**KIRKLEES METROPOLITAN COUNCIL  
INVESTMENT & REGENERATION SERVICE**

Reference No:	<b>2025/70/91332/W</b>
Site Address:	11, Woodlands Avenue, Thongsbridge, Holmfirth, HD9 7SP
Description:	Variation of conditions 2 (plans), 3 (materials) on previous permission 2011/92866 for erection of two storey side extension
Recommending Officer:	Molly Storer

**DECISION – VARIATION OF CONDITIONS APPROVED**

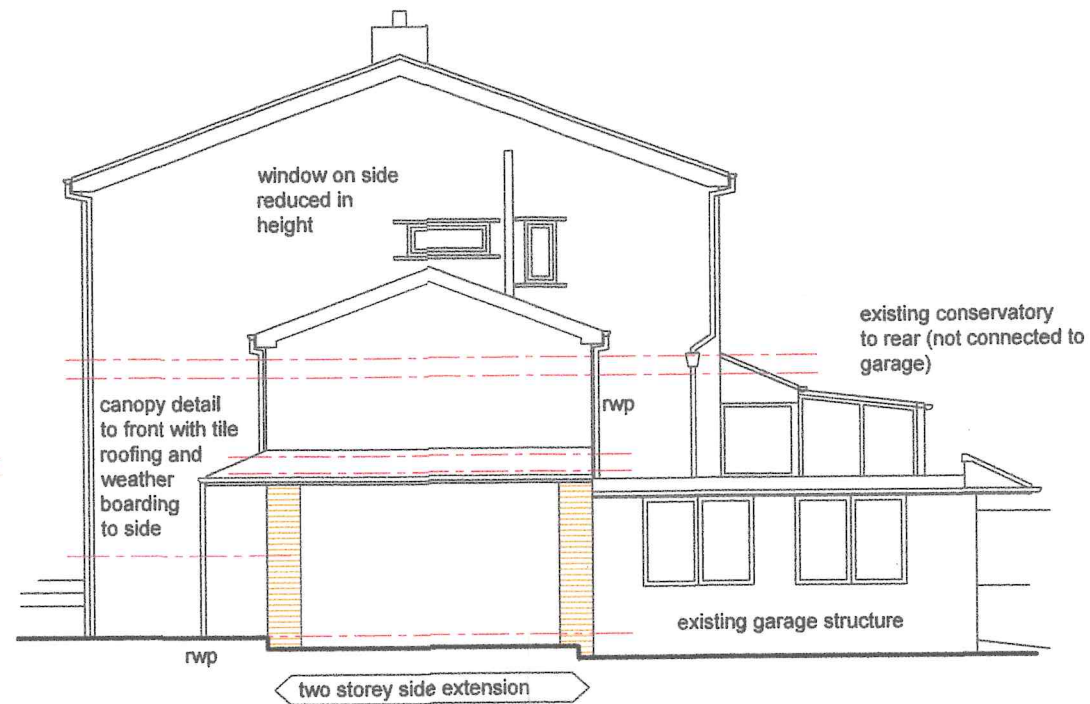
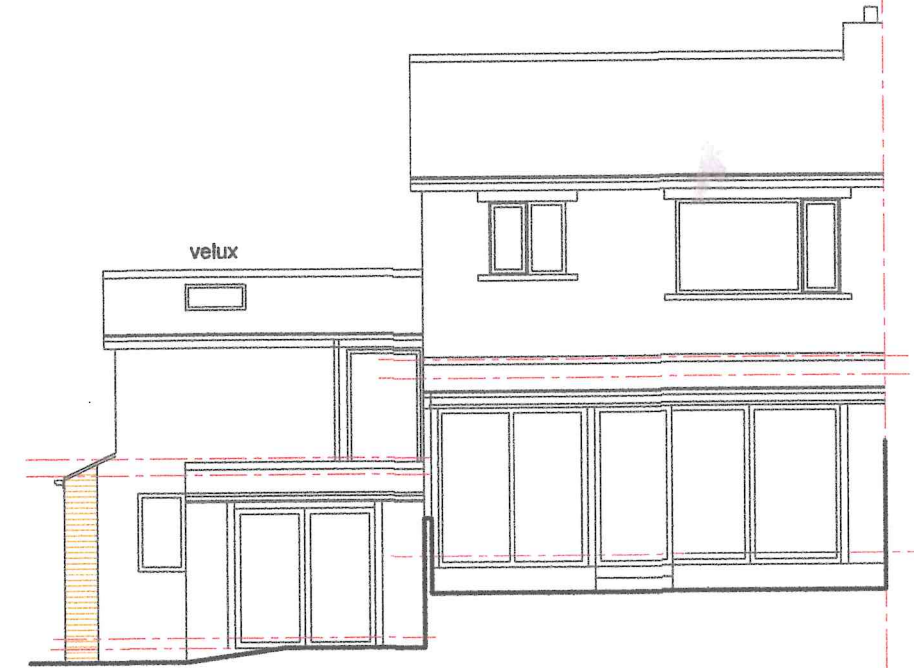
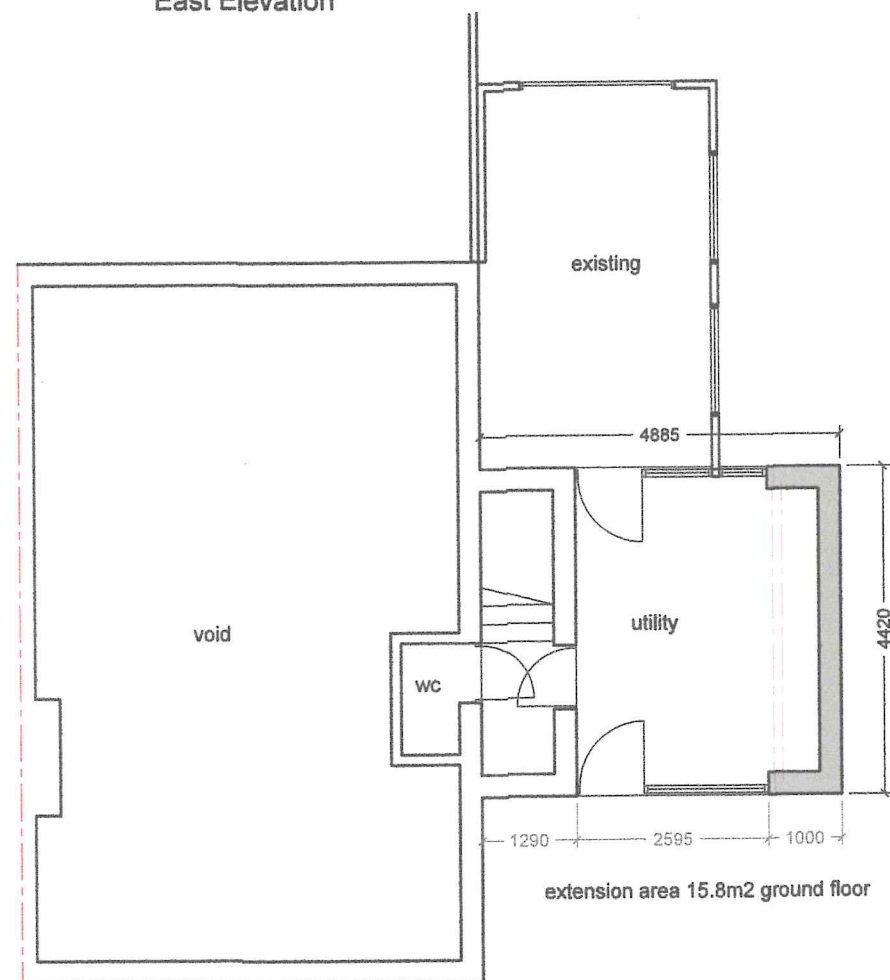
- Change of the facing material on the ground floor side walls from facing brick to block and render with brick corner detailing.
- Reduced width and height of the first-floor extension by approximately ~1m, while keeping the extension within the originally approved footprint.
- Alterations to glazing to the front and rear elevations including two new roof lights.

There will be multiple changes made to the original proposal (listed above). With regards to the change of the facing material on the ground floor side walls from facing brick to block and render with brick corner detailing. This is considered acceptable as it will harmonise with the existing property and surrounding area. the materials of render with brick corner detailing are common within the locality.

The first floor element of the extension will see a reduction in width and height of the first-floor by approximately ~1m, while keeping the extension within the originally approved footprint.

The window changes to the front and rear elevation are proposed to be of a similar size and further within the site than those previously approved and therefore will have no further impact. Although there is are two additional roof lights (one within the front roof plane and one within the rear roof plane) these are not considered to have any significant further impact then other approved openings on the respective elevations.

2. The materials of construction shall be in accordance with those set out within submitted drawing WA05 with the colour finish of all render to match that of the colour finish of render upon the existing dwelling. The development shall not be brought into use until it has been completed
